PLANNING AMENDMENT

H08/1404/02/A1

TWO STOREY EXTENSION TO DWELLING HOUSE

**Proposed alterations and extension to The Firs, Siltside,
Gosberton Risegate for Mr & Mrs D Matthews
Planning Permission Ref: H08/1404/02
Listed Building Consent: H08/1405/02**

Drawing Number:
A0026 - 03
Rev: A

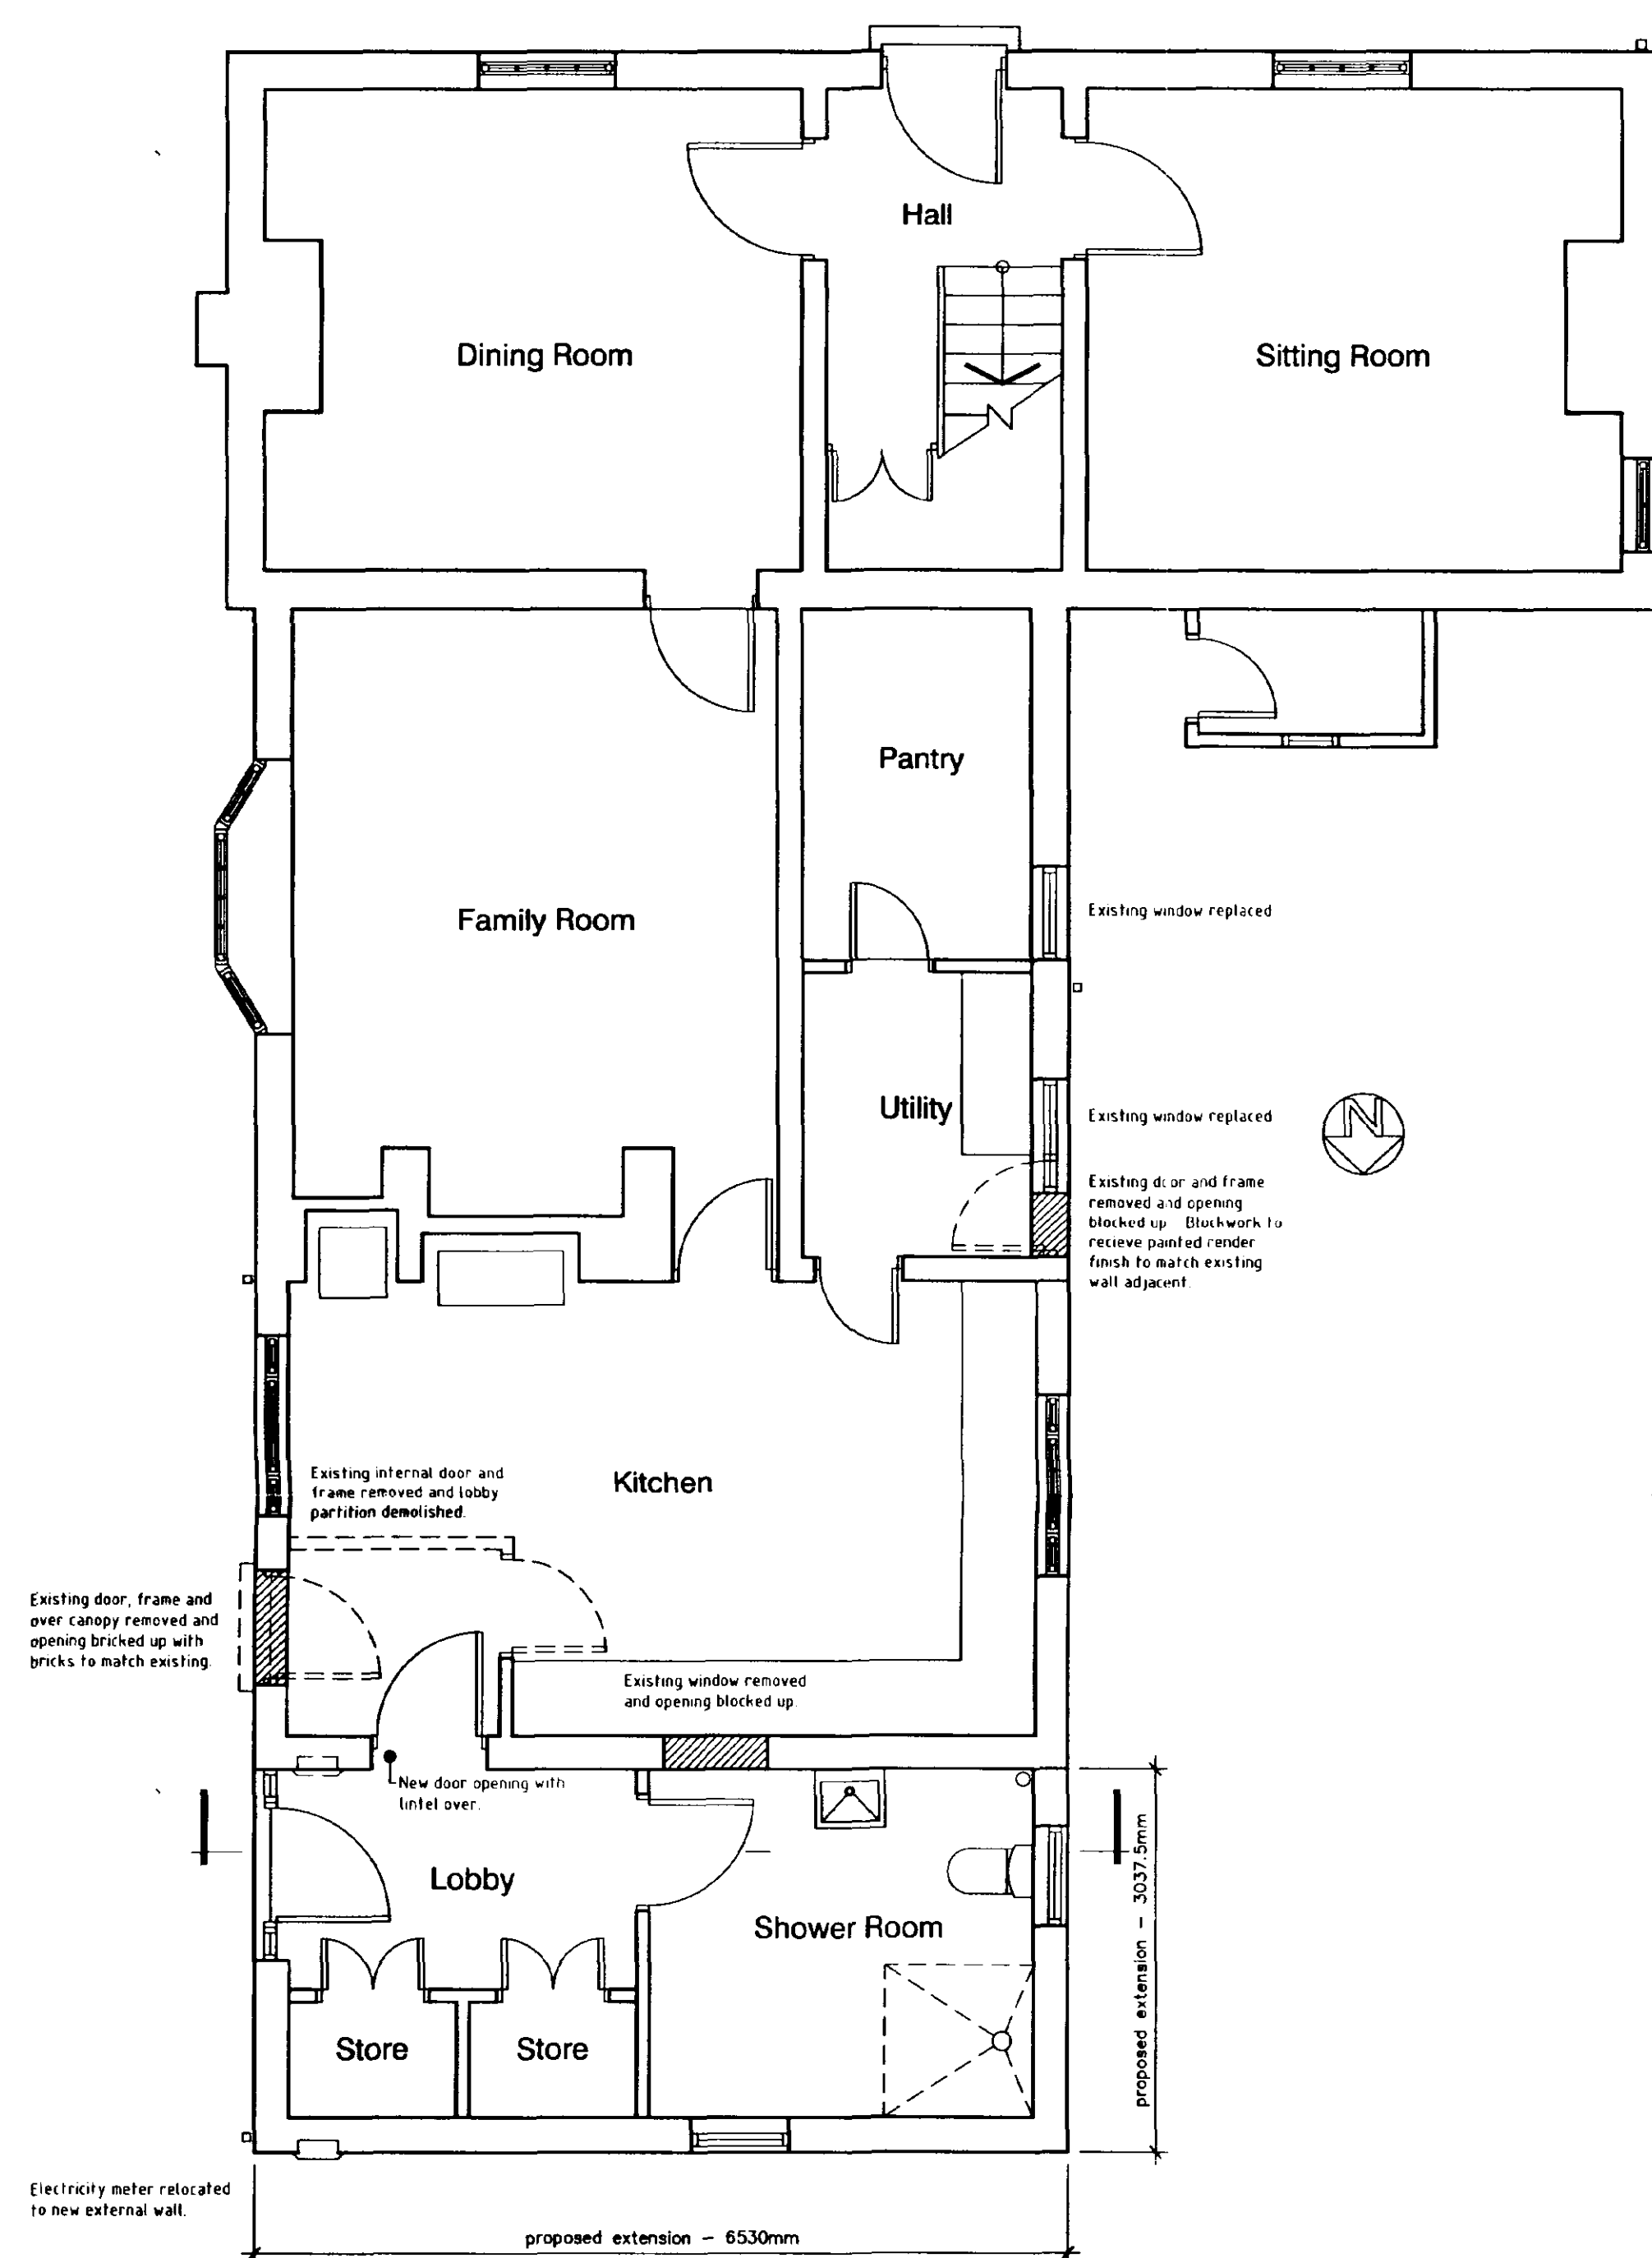
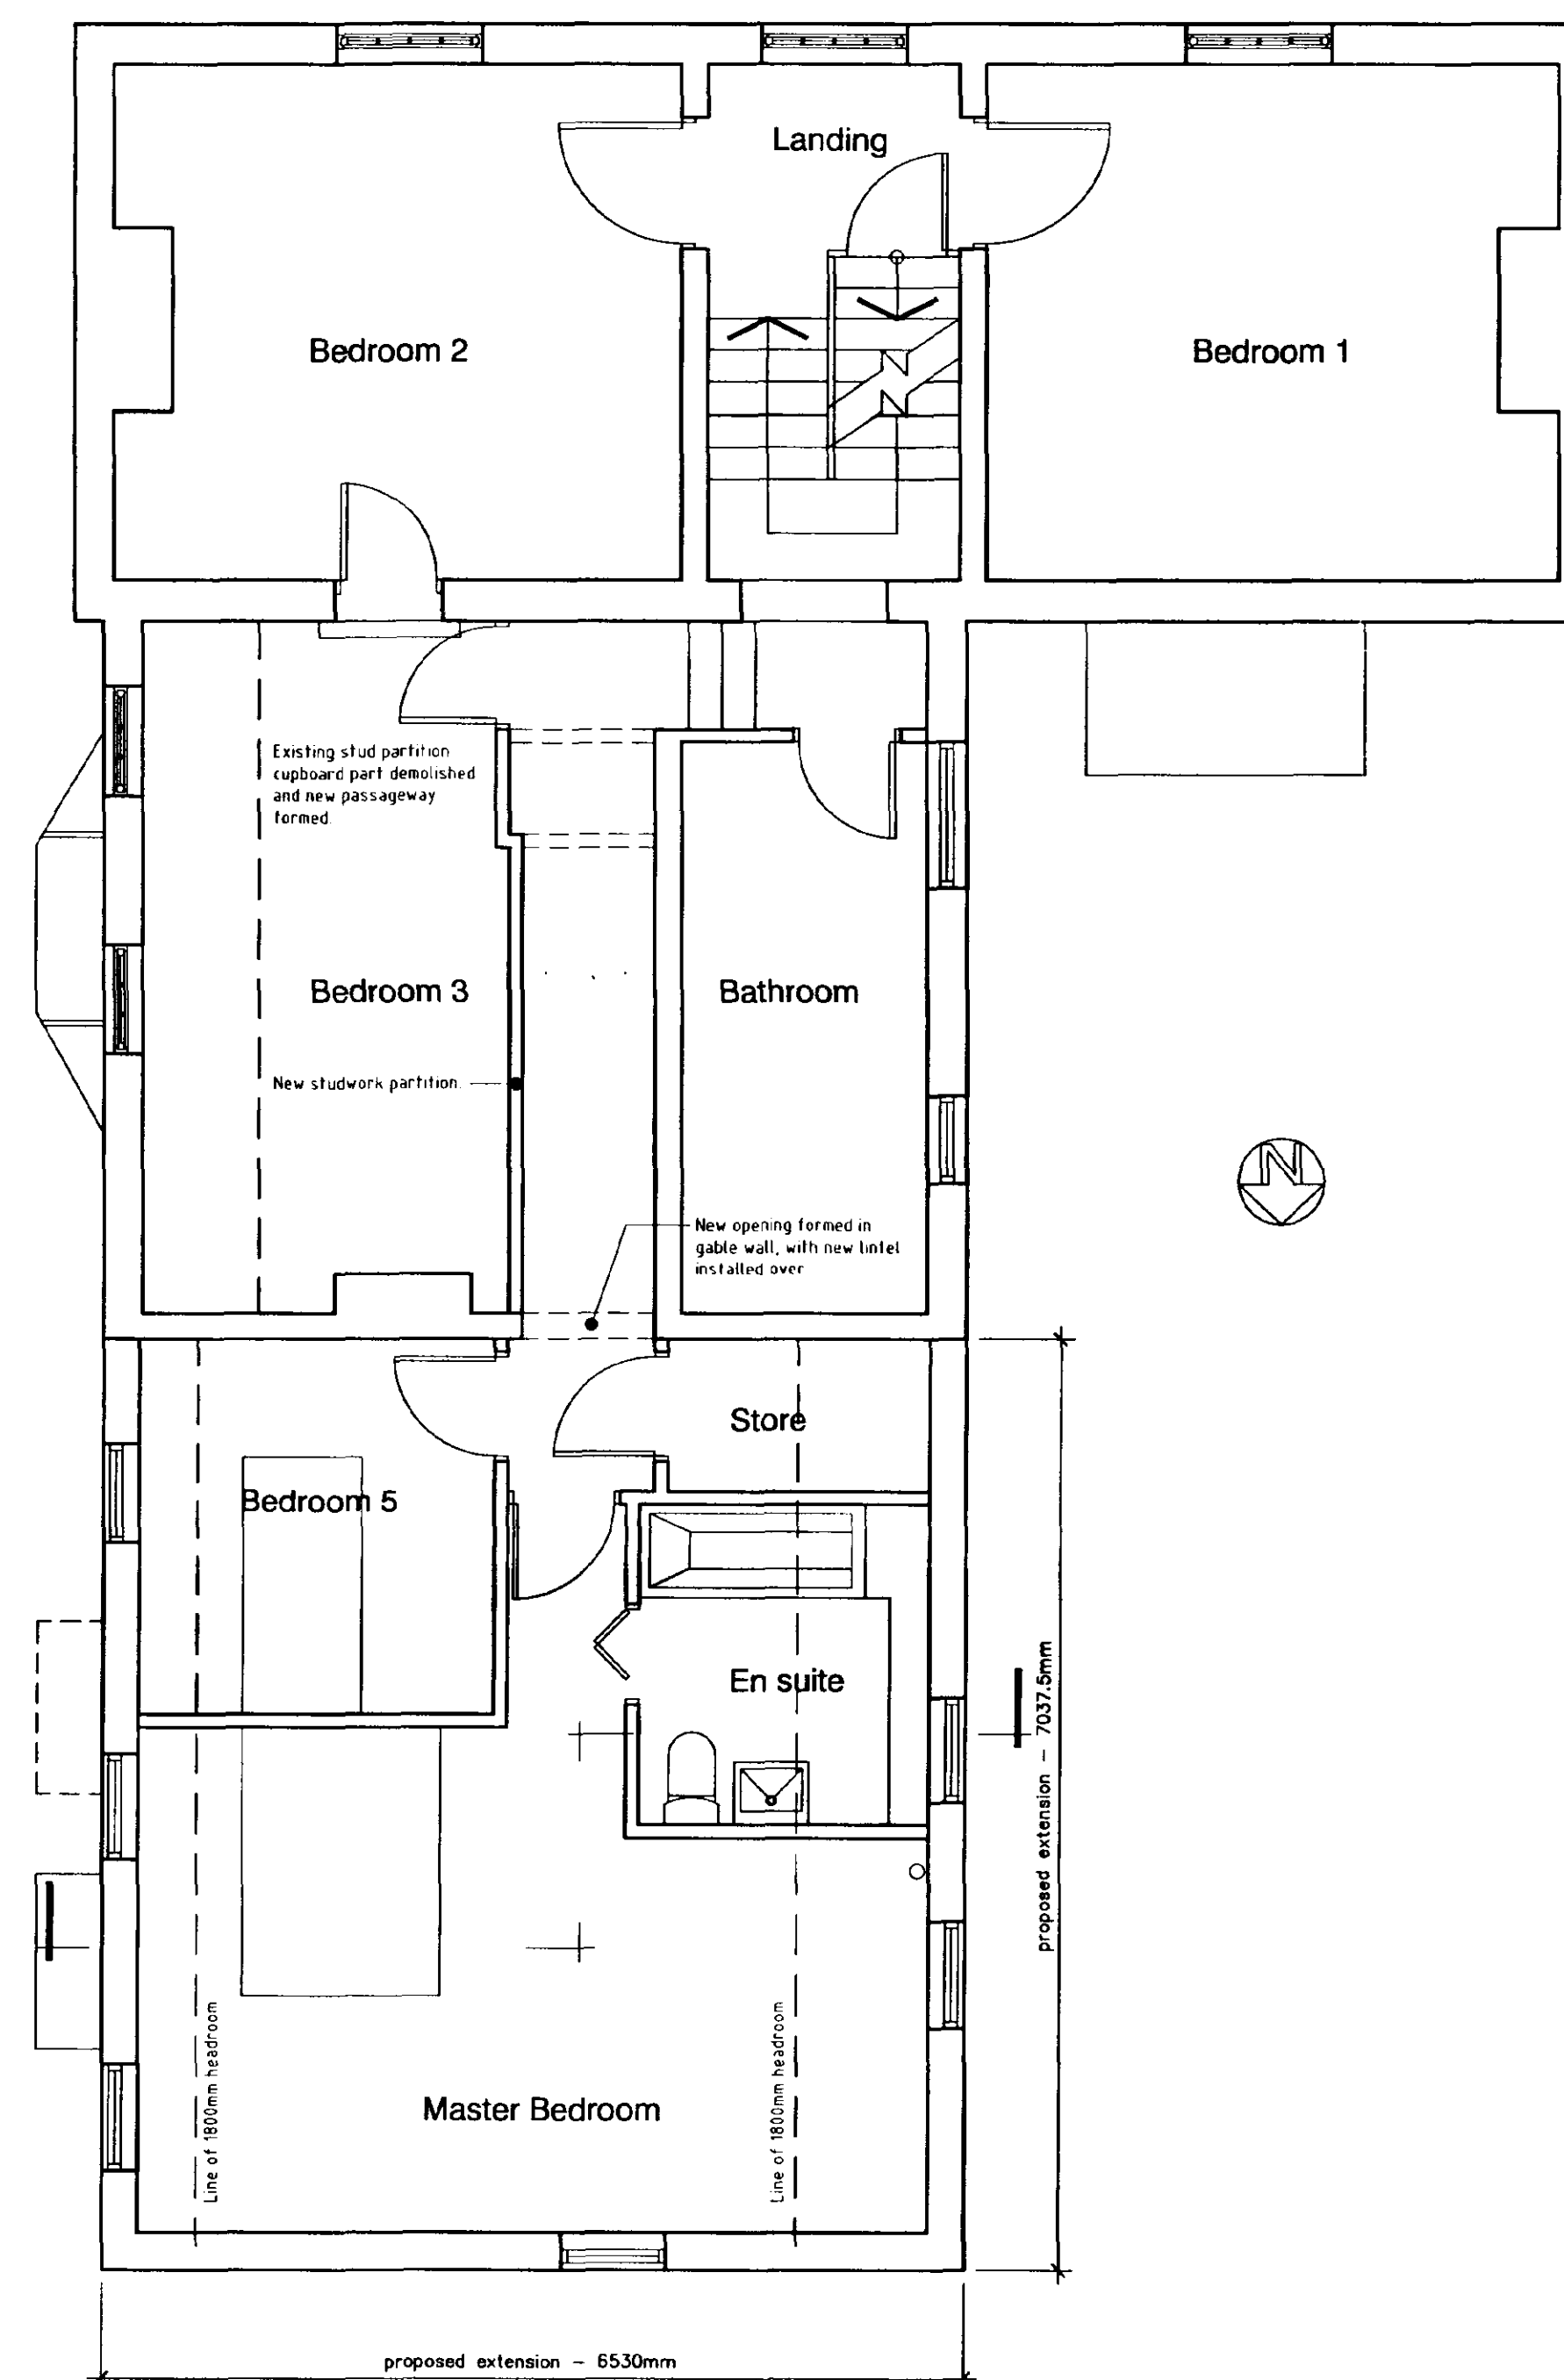
REDUCTION IN EXTENSION SIZE

Amendment: Reduction in extension size
Dwg. nos. A0026-03A & A0026-04A

With reference to the above project for which consent was granted in February of this year we now enclose a copy of the scheme drawings revised to take into account the reduction in extension size required by our client.

The amended details submitted in respect of the above proposal have now been considered and there are no objections to the amendment being implemented to the extent described above.
